REQUEST

Current Zoning: MUDD-O (mixed use development district, optional) and N1-A (neighborhood 1, A)
Proposed Zoning: RAC(CD) (regional activity center, conditional)

Approximately 2.28 acres located on the east side of Apex Drive and north side of Coltsgate Road, west of Cameron Valley Parkway.

The petition proposes a multi-family residential development as part of the Apex Southpark project on parcels currently developed with surface parking and one single family home.

TECHNICAL DATA SHEET

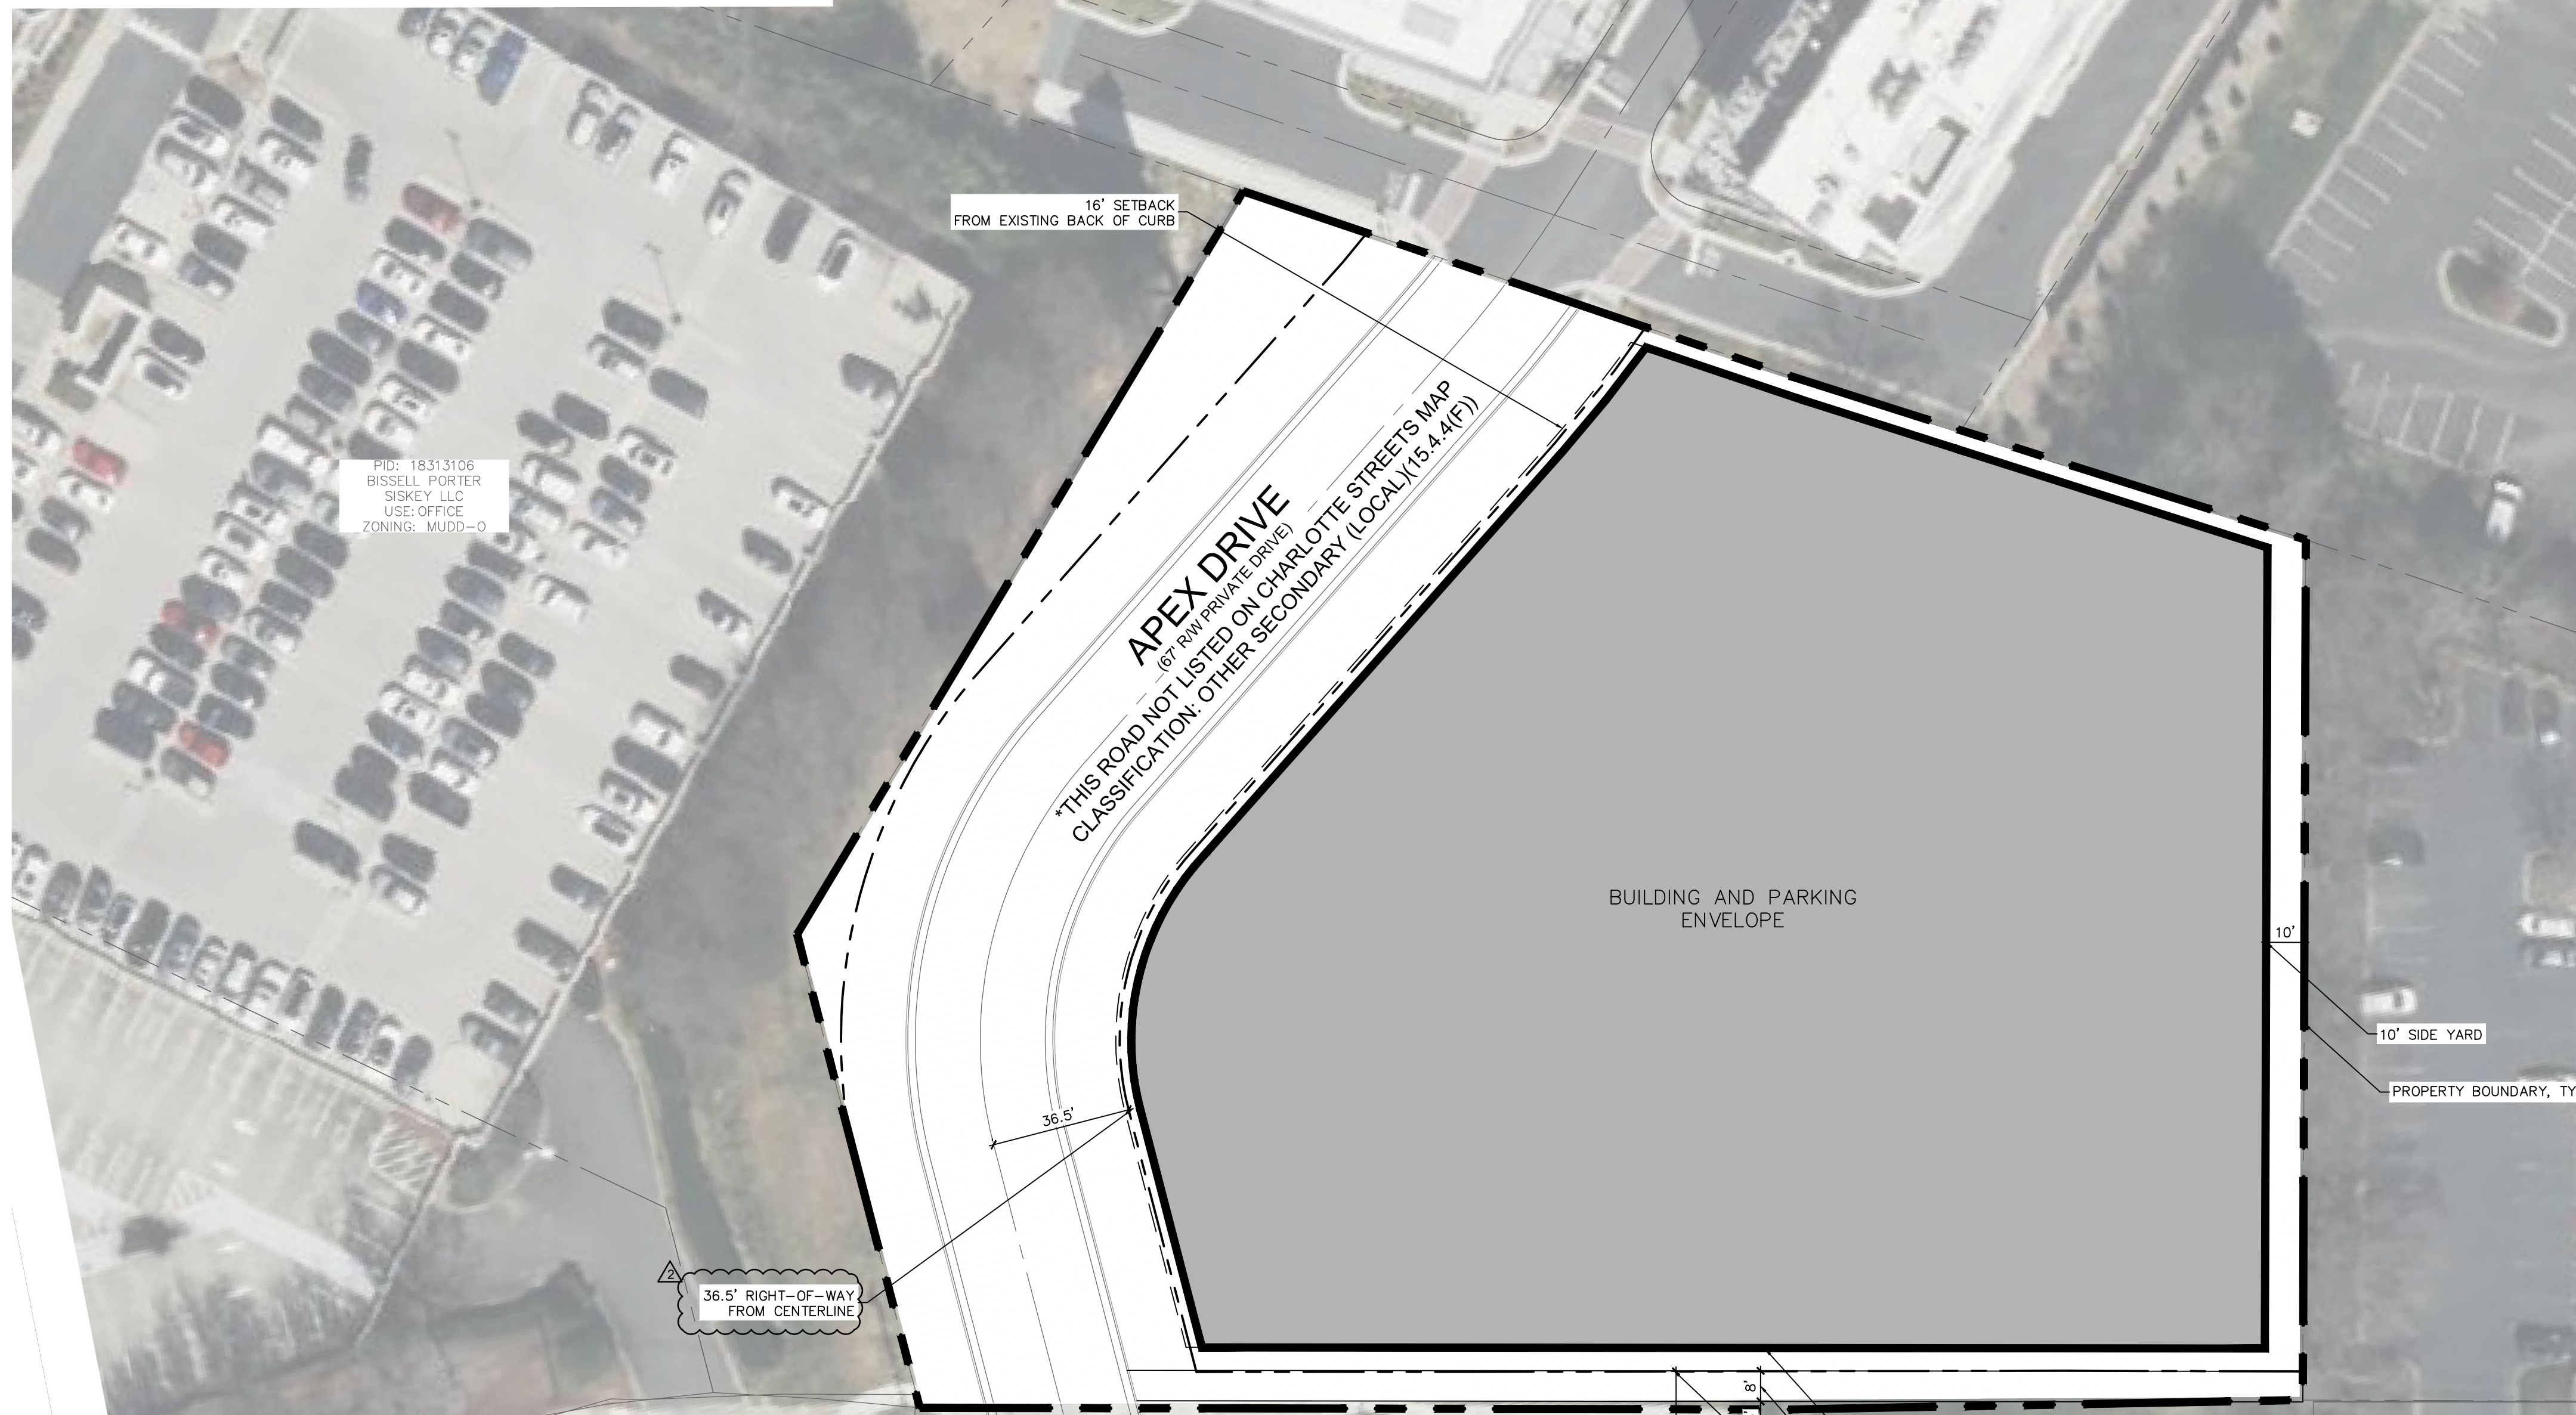
3. Revise Note 1. of the Storm Water Quality Treatment conditions to specify 24% rather than 25%.
-

2. Add a note specifying that any height above 150' will be achieved utilizing development bonus standards outlined in Article 16 of the UDO.
